Application No: FP/18/22/HH
Site Address: 30 Ormesby Crescent Felpham PO22 8EN
Description of works: Demolition of existing detached garage and erection of two storey side extension and single storey rear extension.

Thank you for your internet representation made on 9th February 2022 which has been recorded as an objection with the comments as follows:

sheet 1

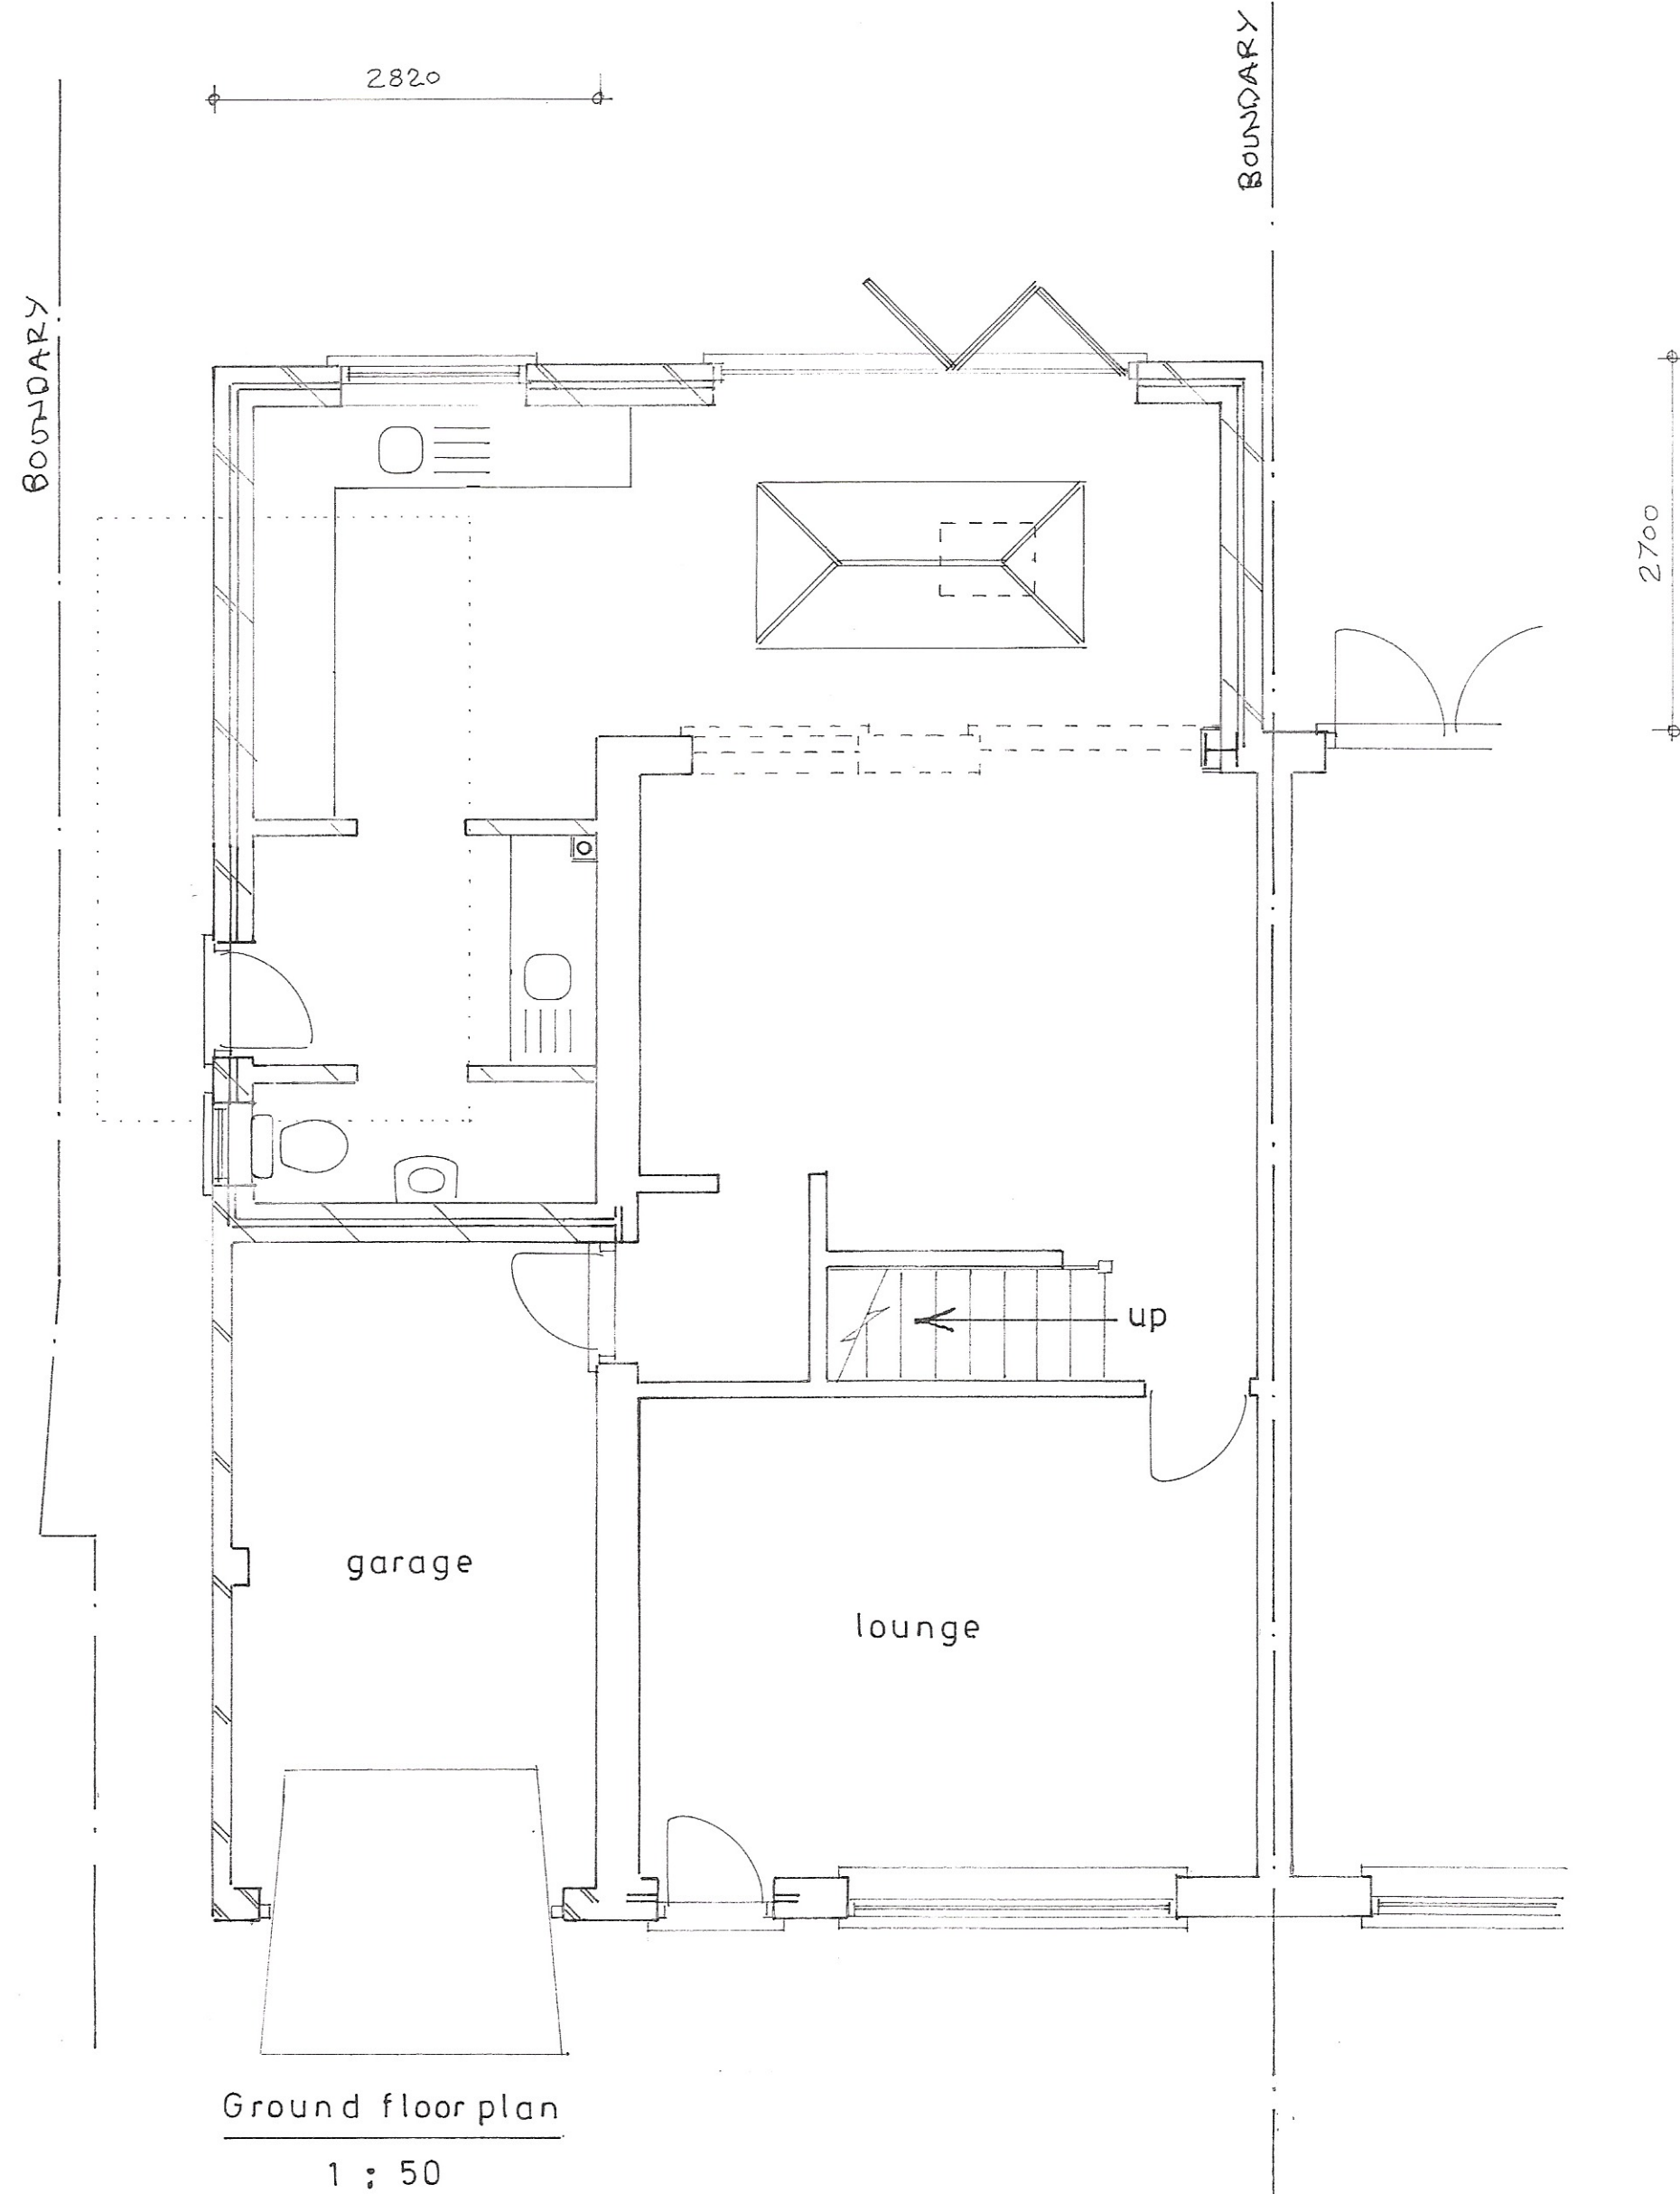
Felpham Parish Council object on the basis that the proposed two storey extension is 0.9m from the boundary and not the required 1m, contrary to planning policy.
